From: Laura Gibbons [REDACTED]
Sent: 04 August 2020 14:35
To: Planning.Responses <Planning.Responses@arun.gov.uk>
Cc: Simon Davis <Simon.Davis@arun.gov.uk>
Subject: AL/57/20/DOC

Thank you for consulting us regarding condition 14- surface water drainage, we have the following initial comments:

Drawing Title: DRAINAGE LAYOUT

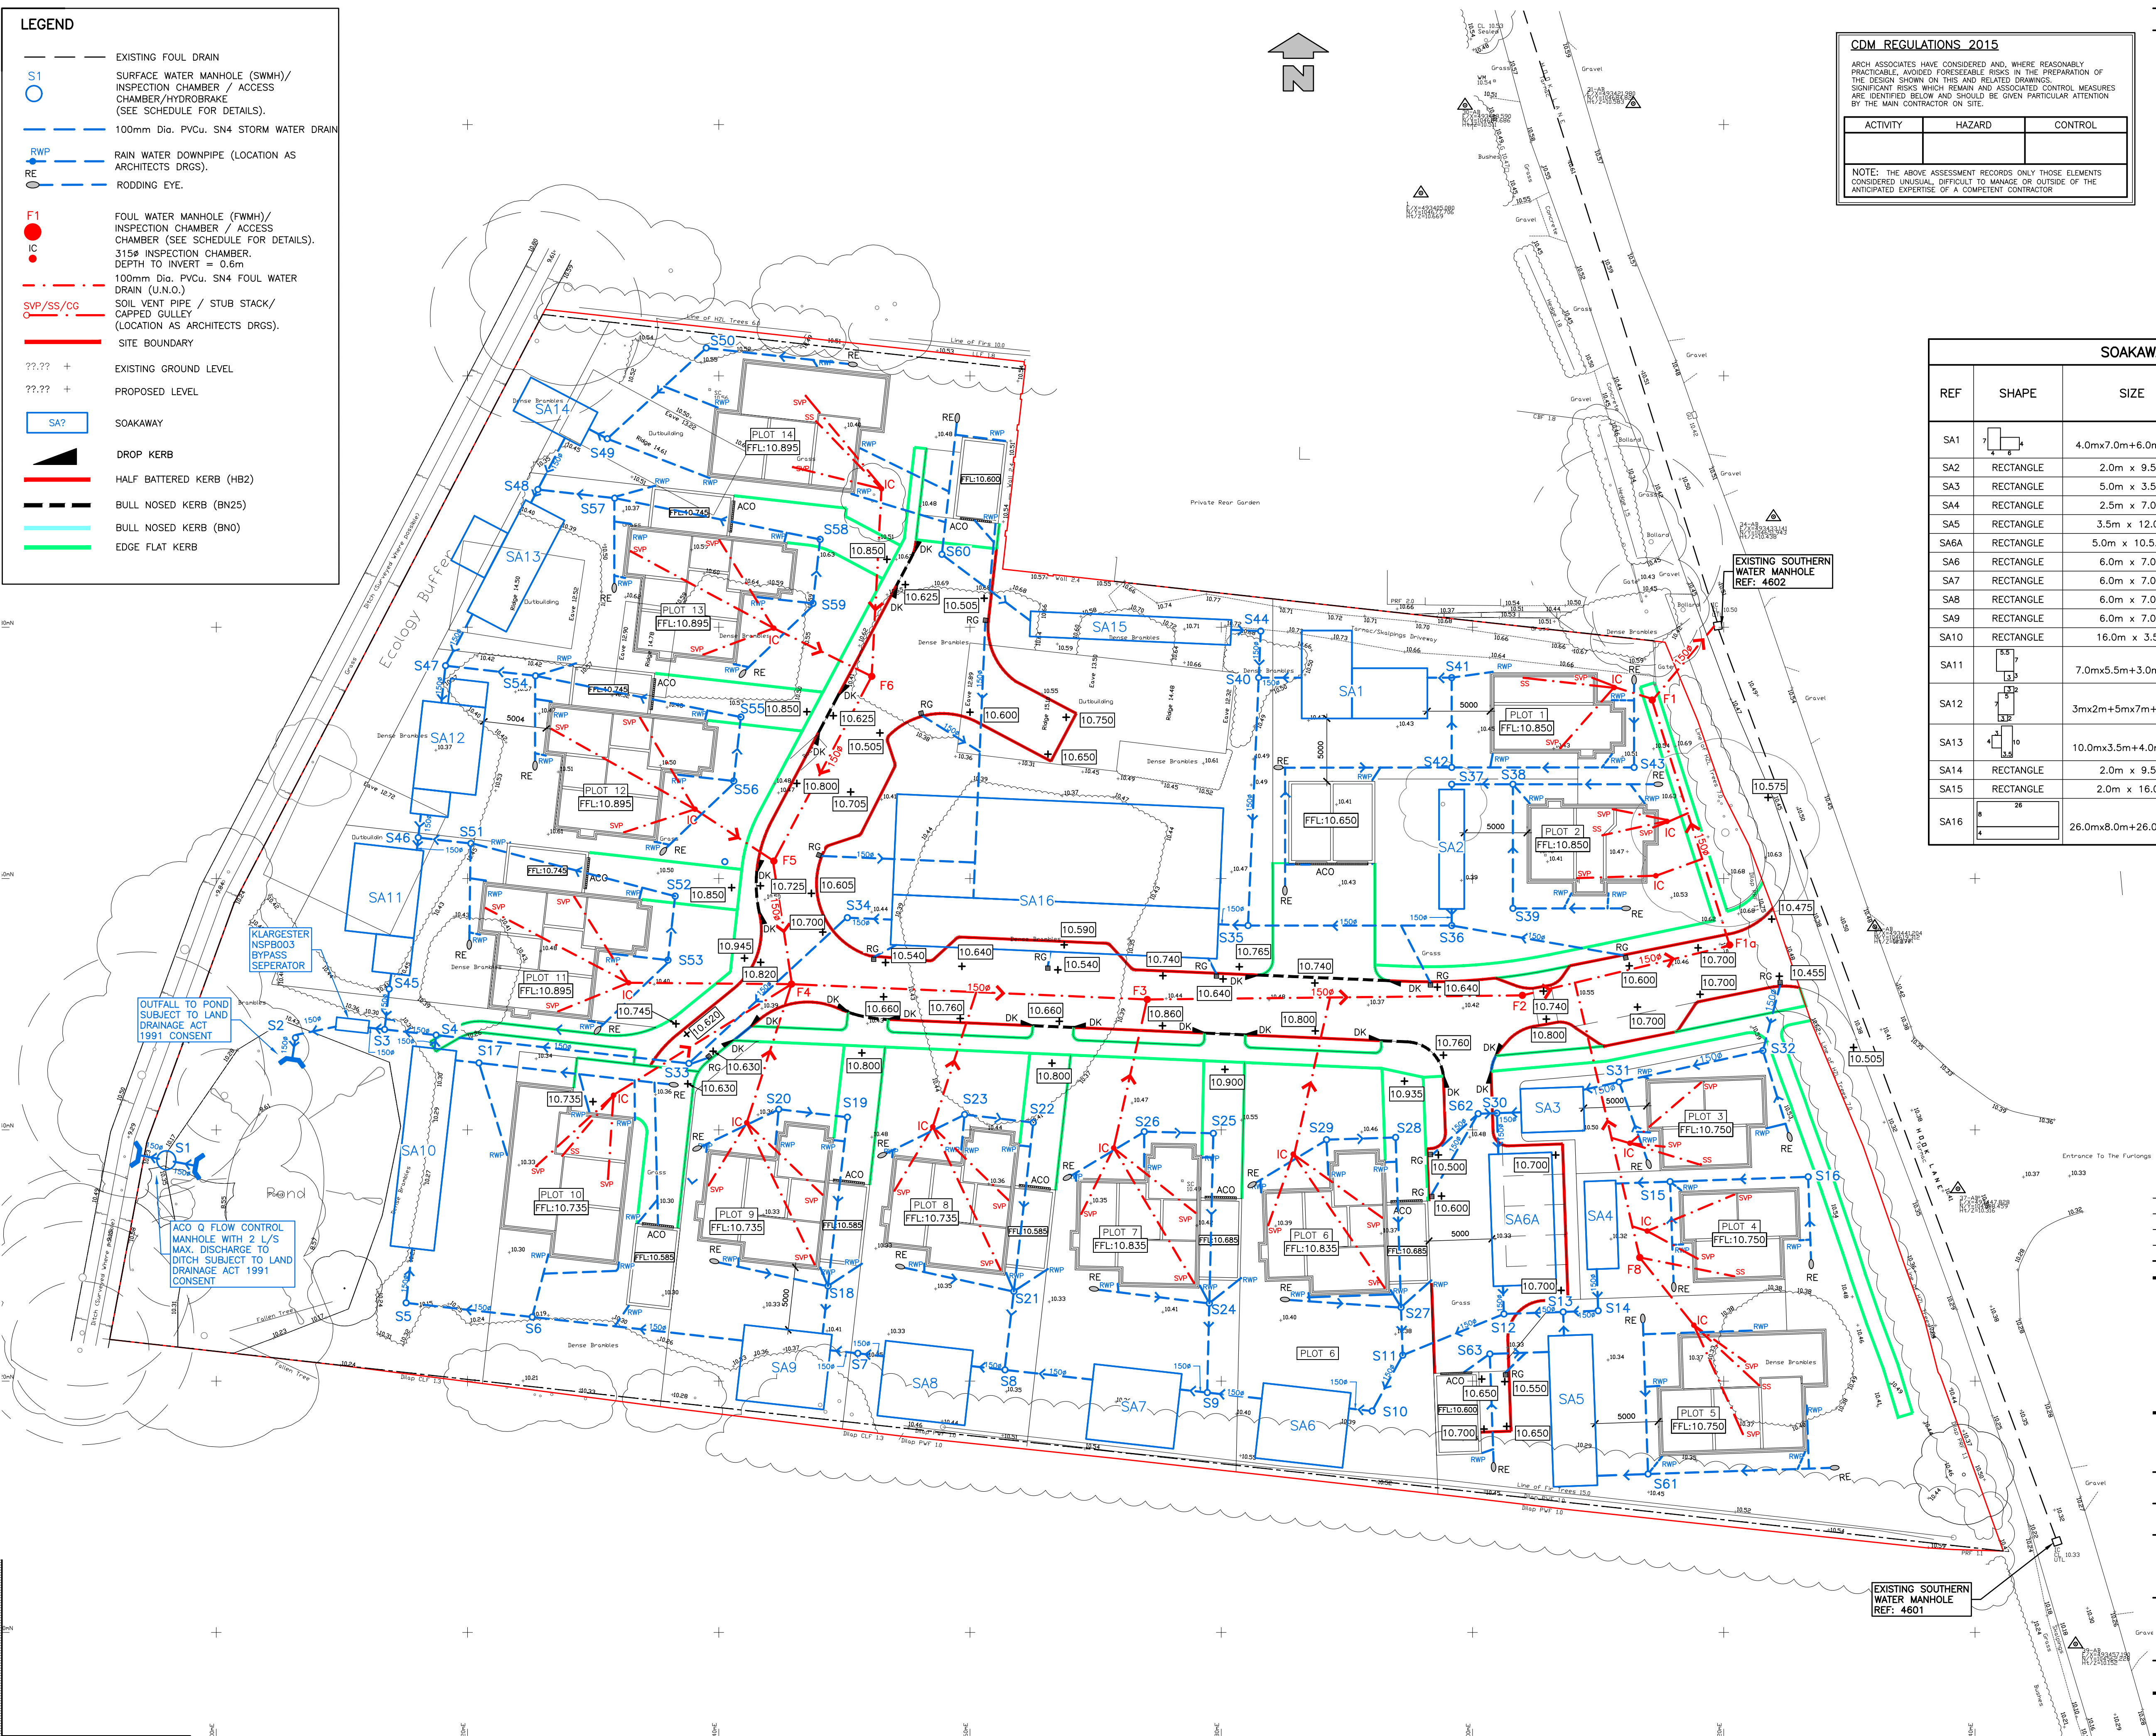
5. SA10 is in very close proximity to the pond, please provide details on how construction will be achieved and if any stability issues are foreseen.
6. Catchpit manholes are required prior to all connections to soakaways.

9. Arrangement around S3, S2 and pond could be improved. Currently significant angles are included in design.
10. The Maintenance and management manual will be reviewed once design has been agreed.

MANHOLE WITH HYDRO-BRAKE (1:25@A1)

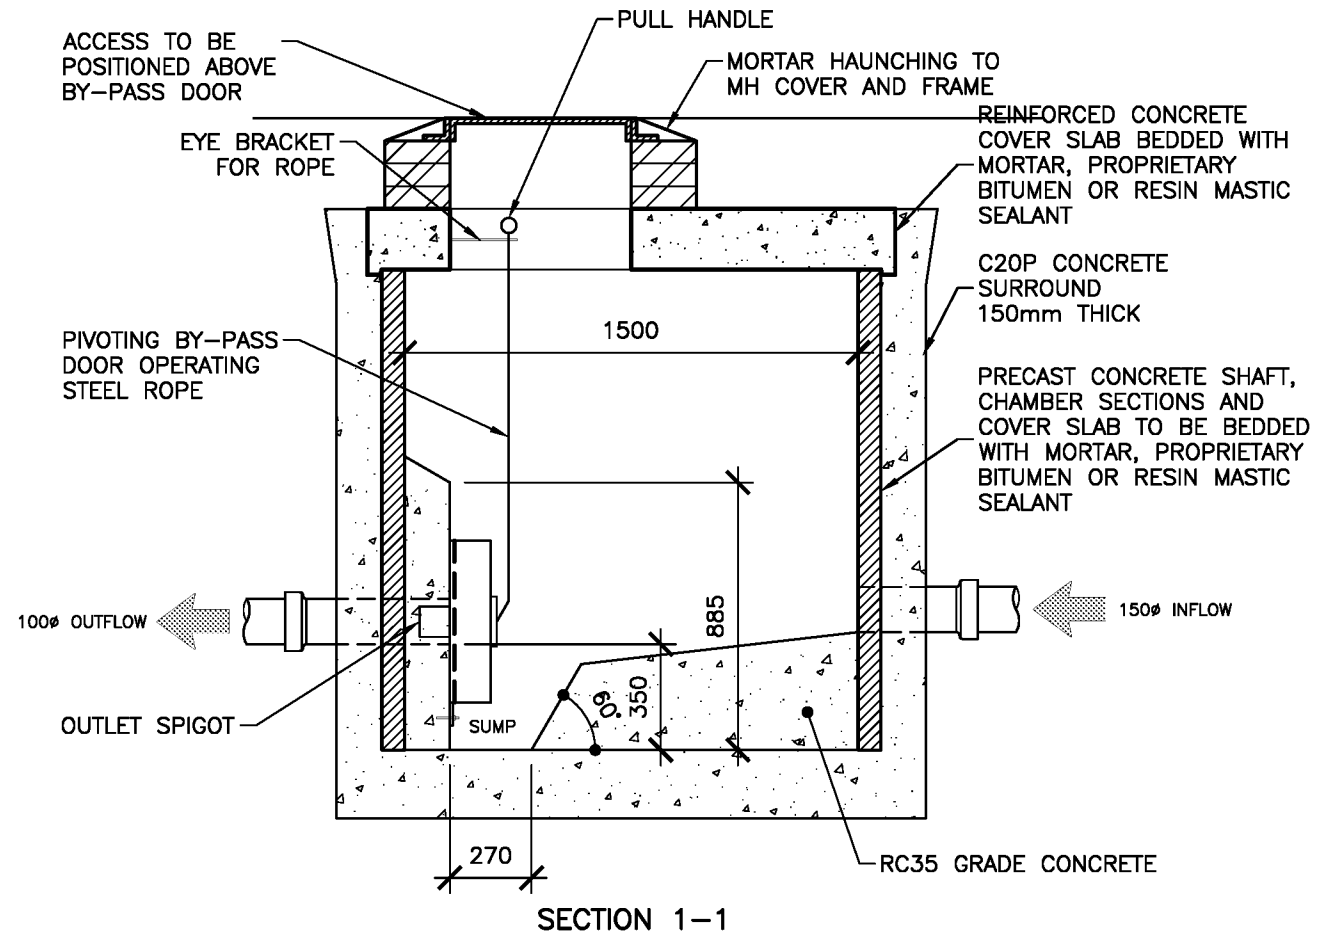
11. Please provide a site specific construction detail drawing for the hydrobrake.
12. Please provide construction detail drawings of pond showing inlets and outlets.
